**Native Sun Construction Preliminary/Final PUD Plan and Filing No. 1 – Final Plat
Response to Review Comments
December 2021**

SHOP ELEVATIONS

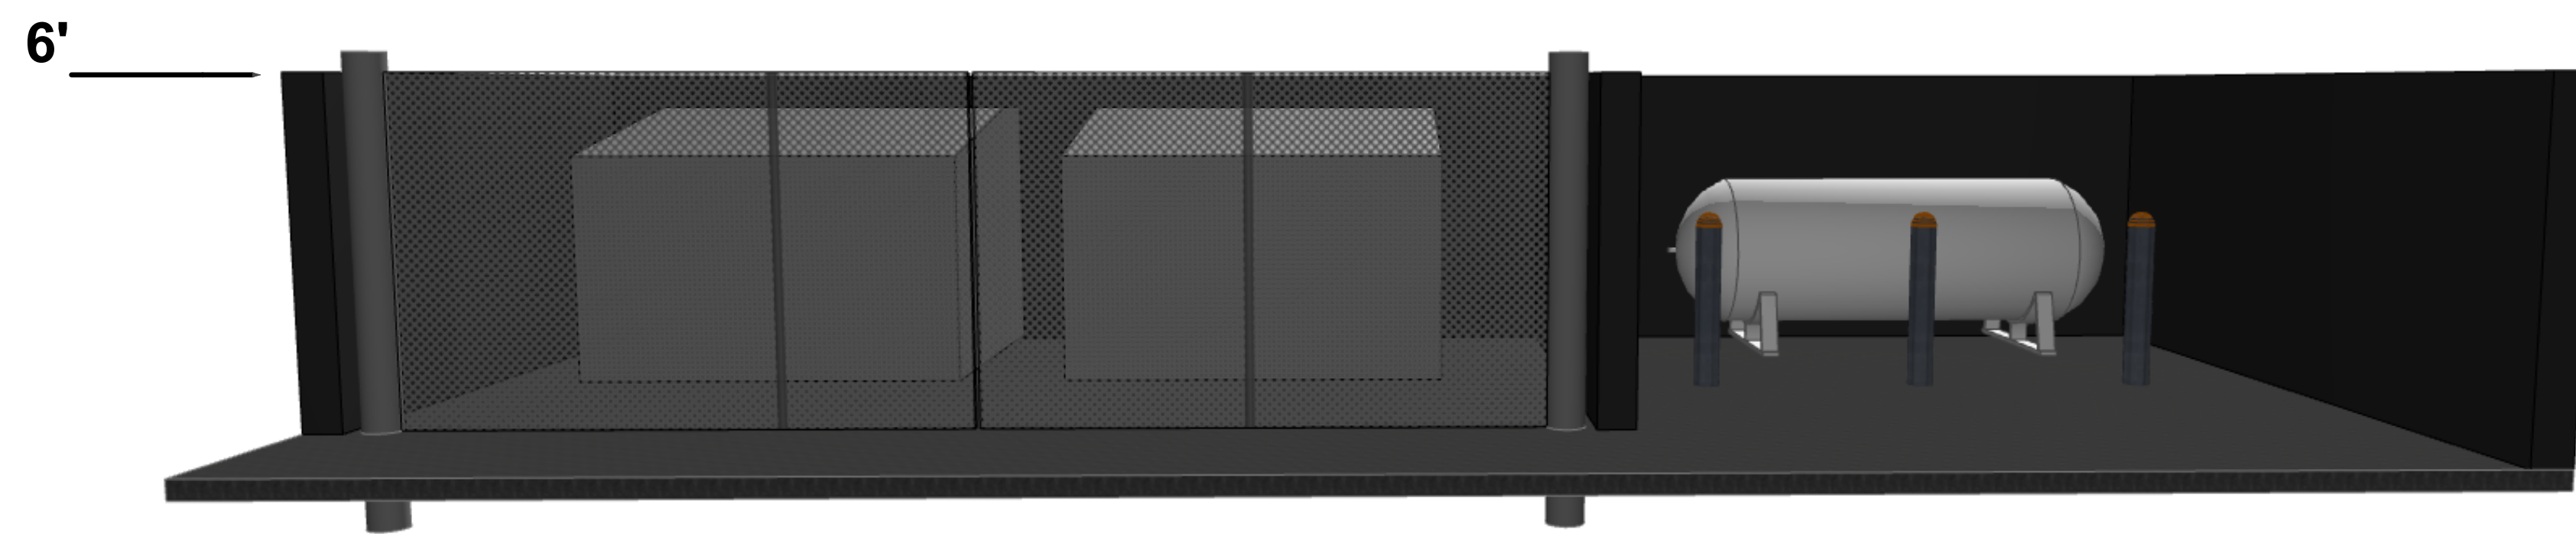
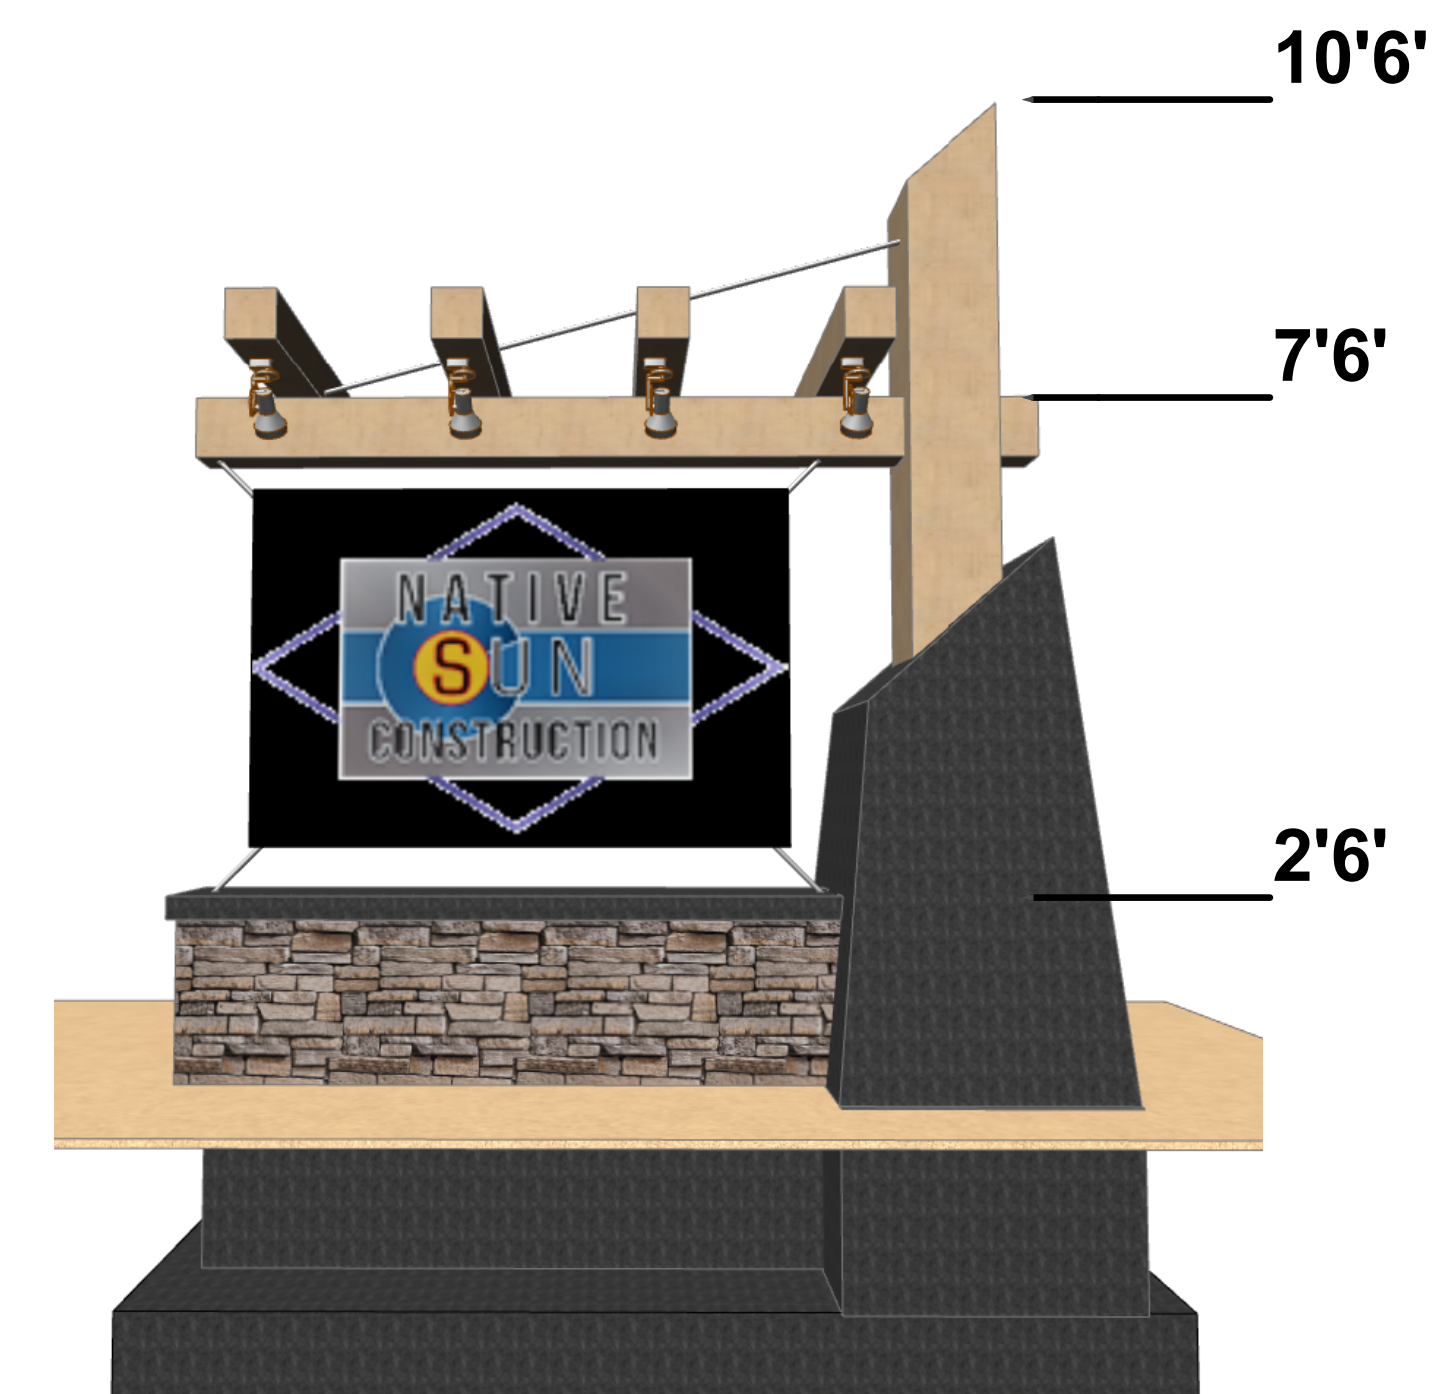
21. Please title this plan sheet as Details rather than shop elevations.	We made this revision.
22. Please show the site fence as an opaque fence.	We made this revision.

PROPOSED
DRAINAGE
PLAN

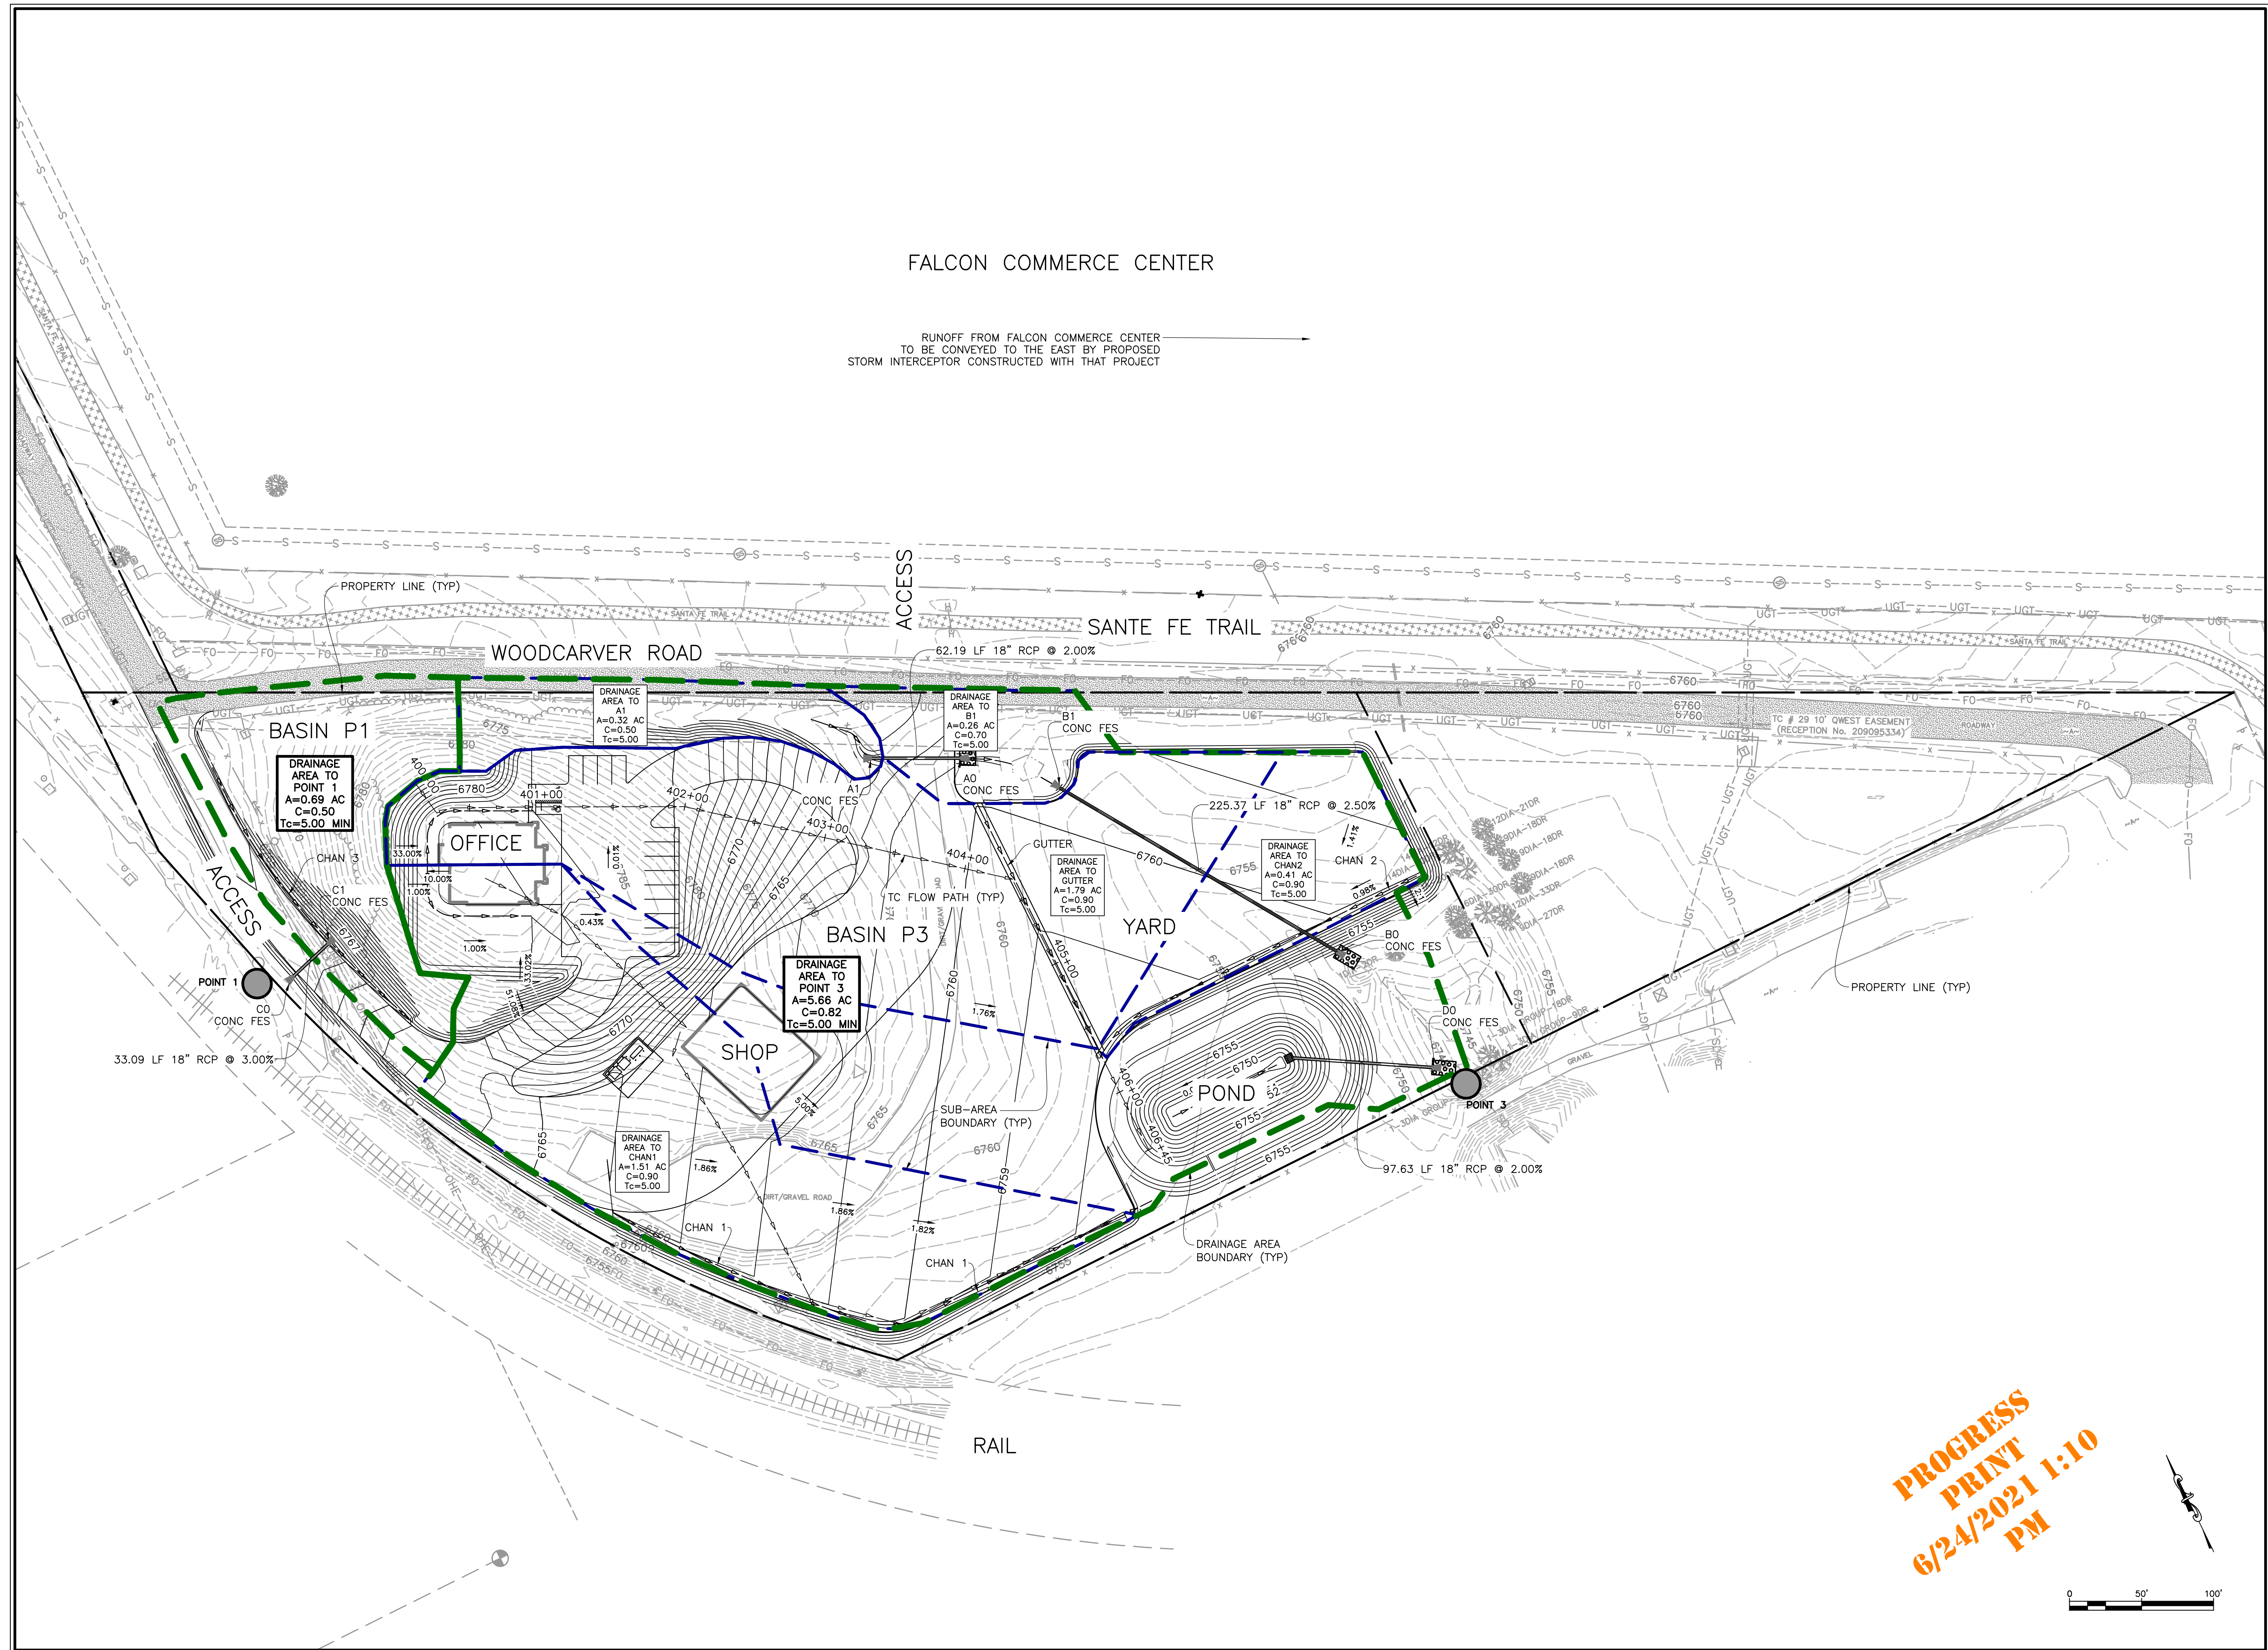
2. Add channel stabilization calculations and add channel lining to plans if necessary. Velocities are high and may cause erosion.	Added riprap lining to the plans and calculations to the report for the steep section flowing towards C1.

3. Include riprap size and depth calculations and add dimensions to plans	Added to Proposed Drainage Plan.
4. Basin area hydrograph does not match pond inflow rates	The required design methodology for an extended detention basin utilizes the Colorado Unit Hydrograph procedure. The other elements of the site utilize the Rational Method for discharge calculation. Per your comment we have matched times of concentration more closely for the sub basins as they correlate to the overall pond unit hydrograph. Hence, you are correct but the two methods will still yield slightly different results. However, the sum of the rational inflows are now are much closer to the inflow generated by the CUHG.

DETAIL—ADA SPACES

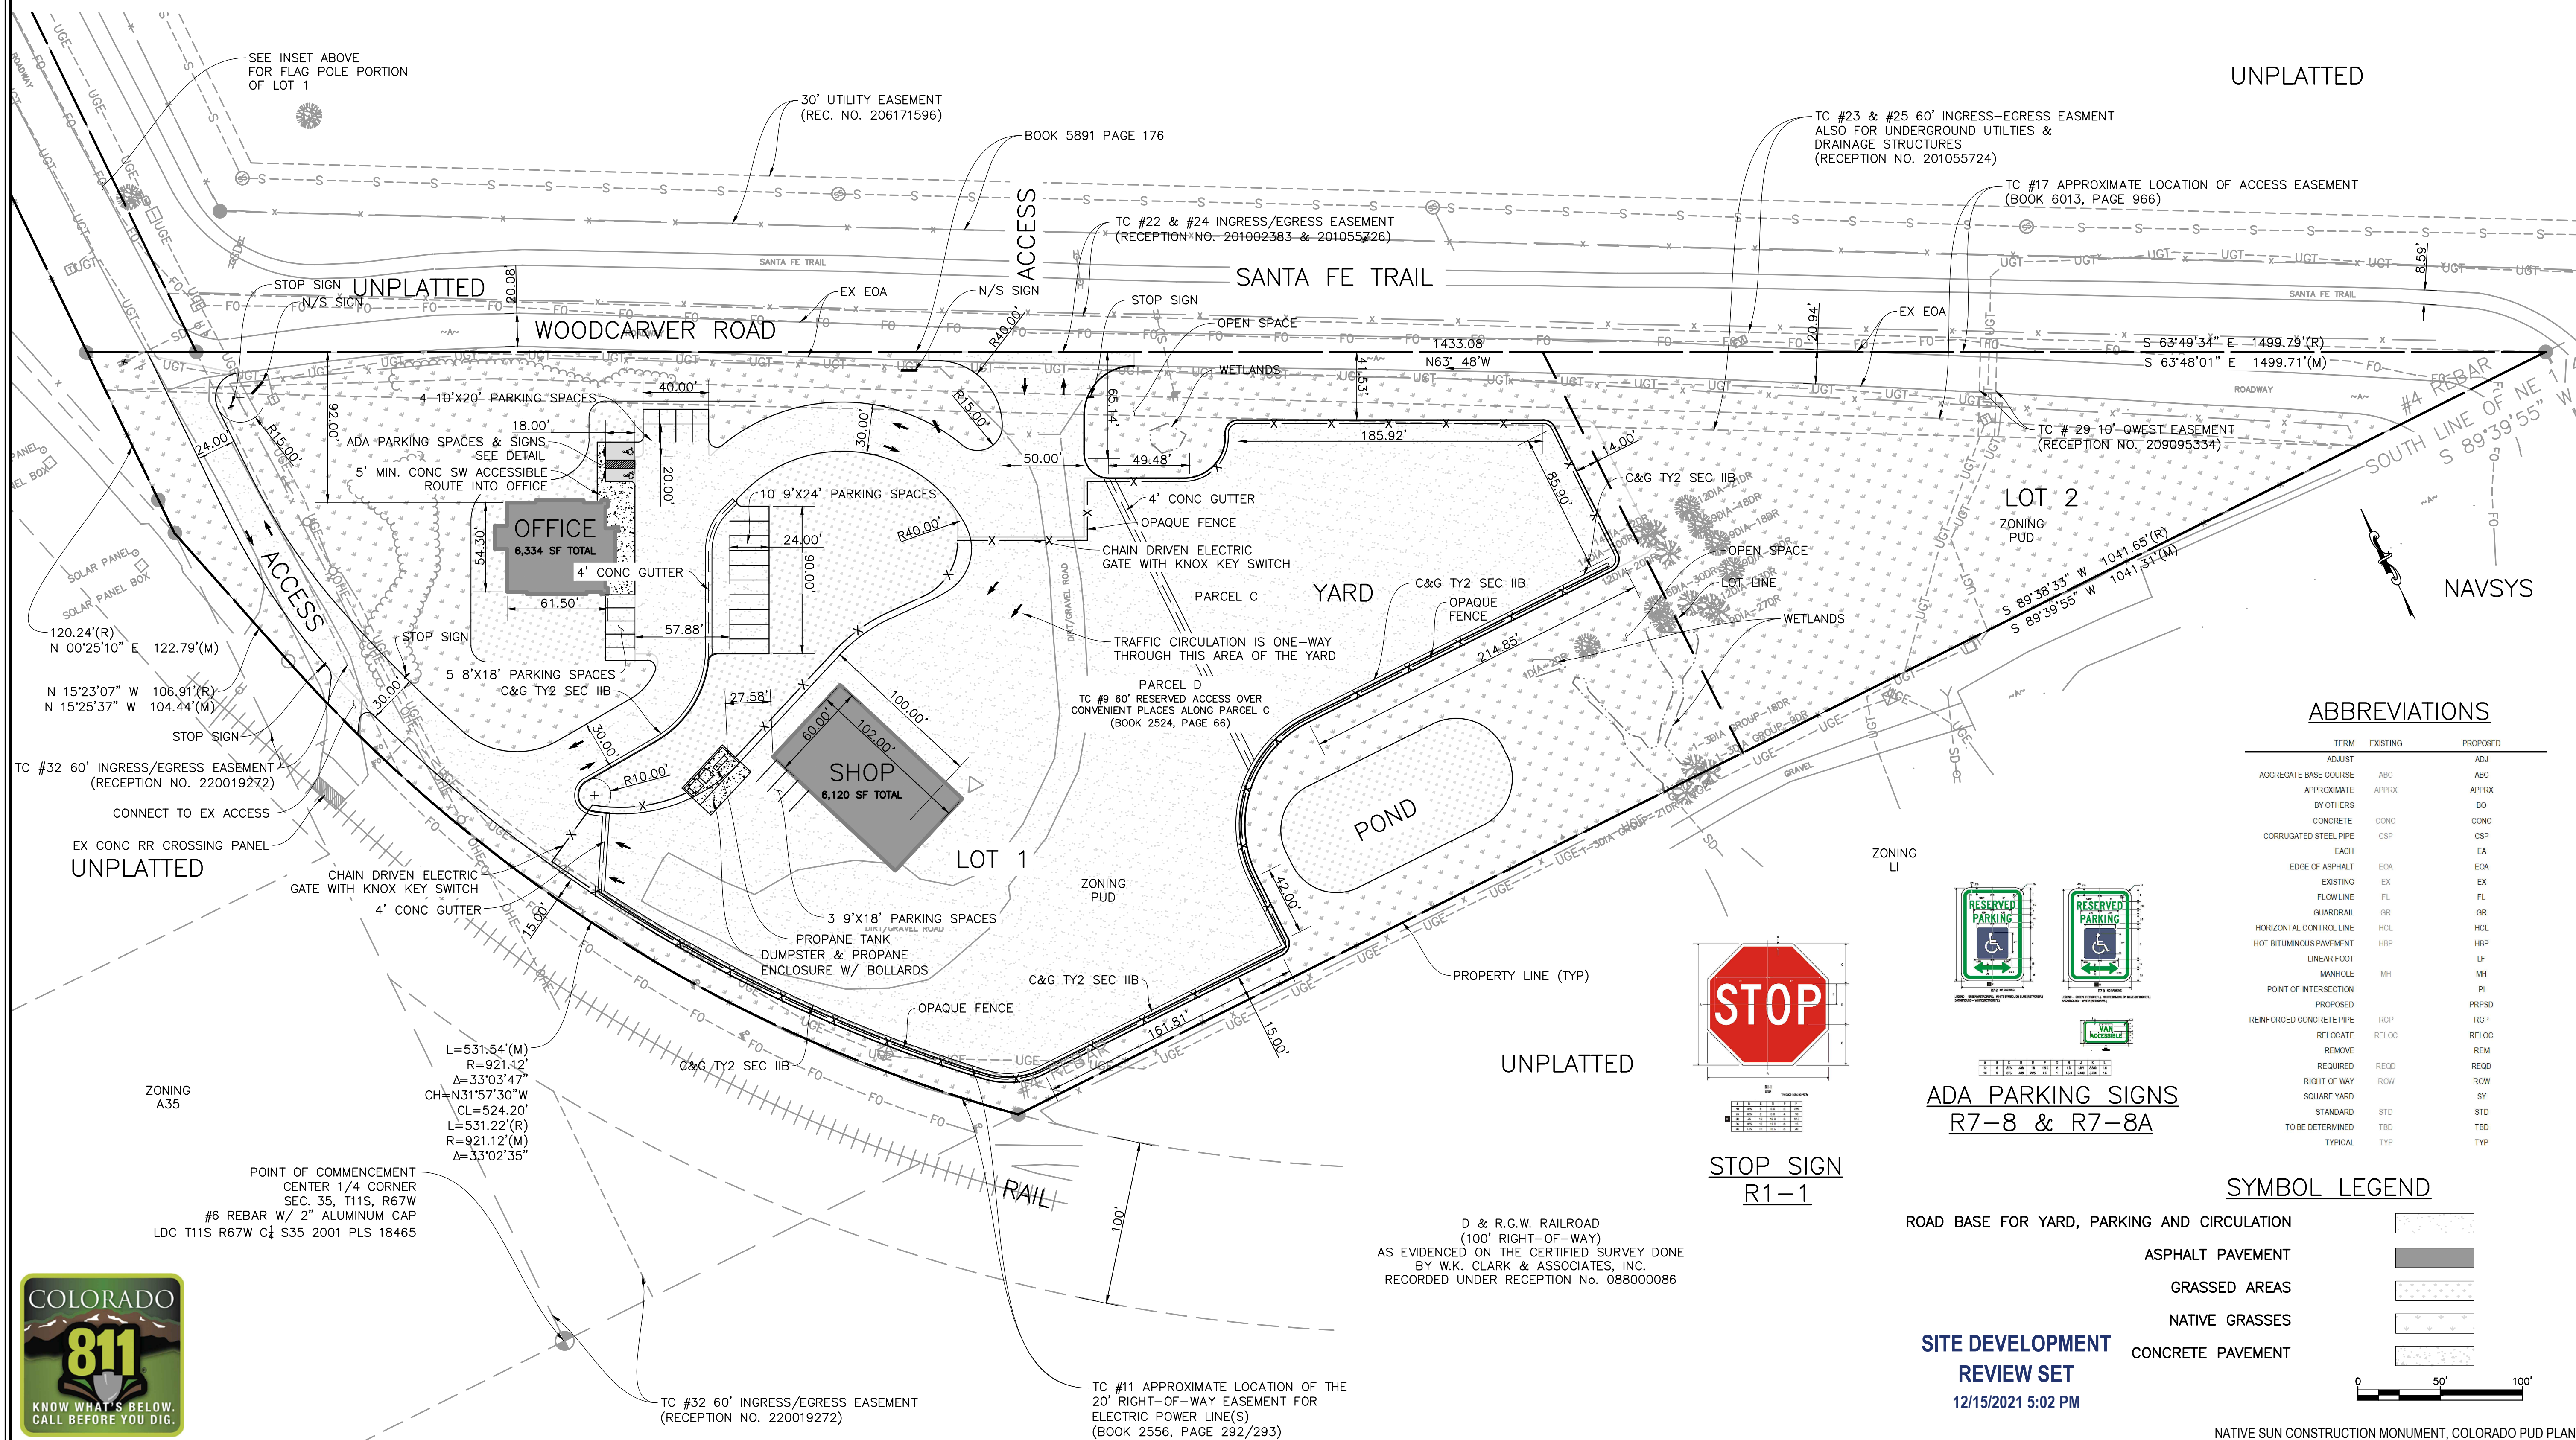
8. Dimension should be provided from shop to propane tank to verify that minimum offset has been met.	Dimension provided and tank labeled.
9. Per ADA requirements, 1 ADA space must be van accessible. Revise plan to accommodate 132" of parking width for van accessibility.	Complete.

10. ADA spaces are required to have ADA parking signs. Please add. Van accessible space should have appropriate plaque.	Added these signs to the sheet.
